SUBJECT: BRES2507-0048
BUILDING RESIDENTIAL

Here are the results of all Inspections located at **51 OXFORD WOODS DR:**

NOTES & DRAWINGS

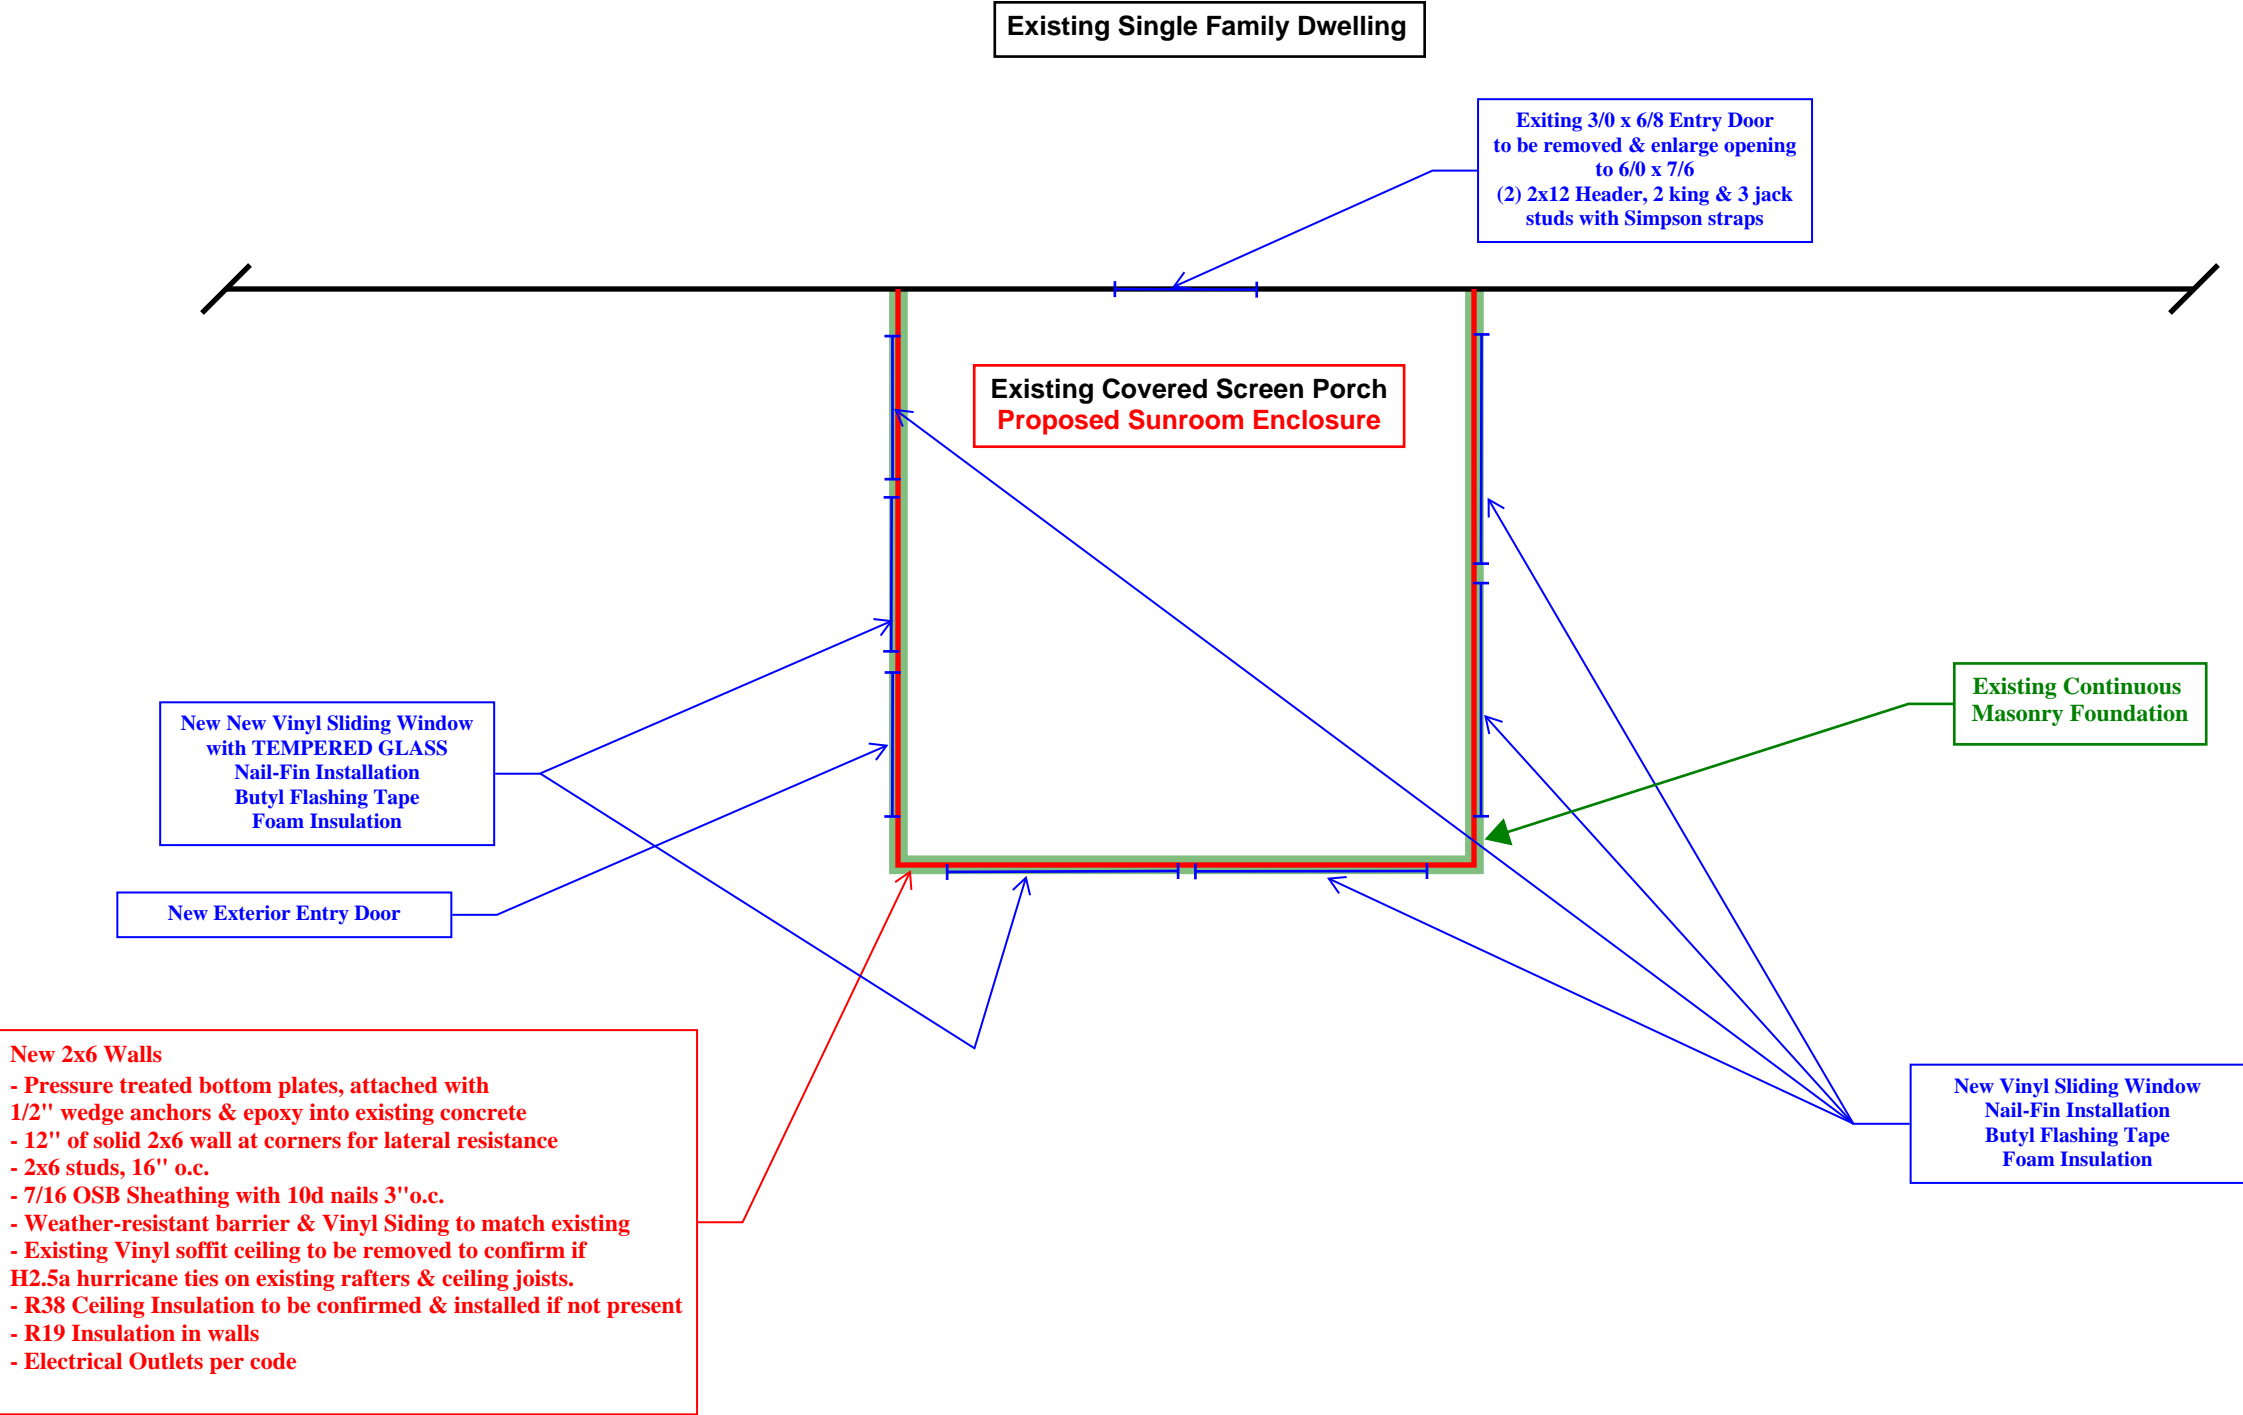
Notes: Anchor bolts missing at wall on door side. Ok to insulate. leave insulation up to see anchor bolts
